M54 to M6 Link Road

TR010054

**8.8P(C) Draft Statement of Common
Ground with Historic England**

November 2020

Location title: View south from the first floor of Hilton Hall
Camera model: Canon EOS 6D
Focal length: 50mm
Field of View: 65° (Horizontal)
Camera height: 1.6m
Photo taken: 02/08/2019
Coordinates: 395199, 305176
Elevation: 156m AOD

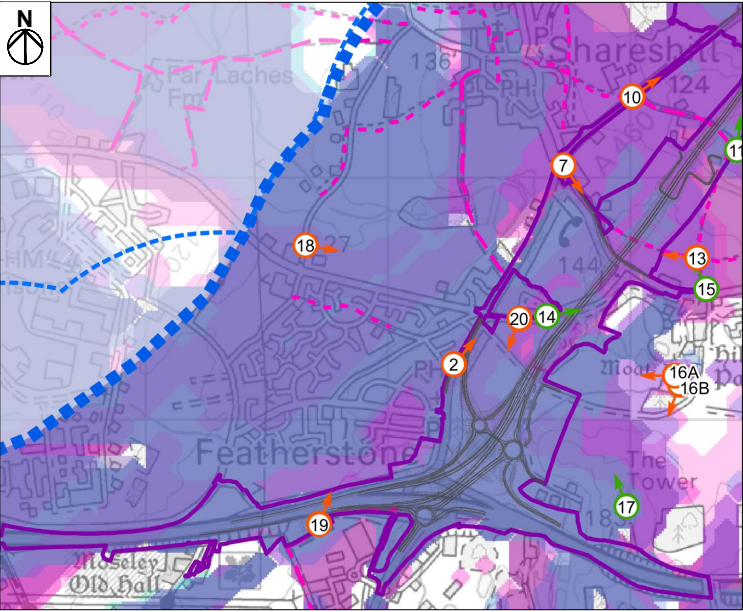
Chapter 6: Cultural heritage [APP-045/6.1]	Section 6.9 'Assessment of likely significant effects' Para. 6.9.12	Construction impact, Grade I listed building 'Hilton Hall'	Historic England query the assessment of impacts on Hilton Hall without it being evidenced that the Scheme would be screened from the hall by existing vegetation. The impact would be considered by Historic England to	Viewpoint photographs Figure 6.5 and 6.6 [APP-076 and 077/6.2] illustrate current views from the hall and have been added to the ES to evidence this. The quotation provided by Historic England is from a superseded	Under discussion	Medium – pending additional Photomont age.
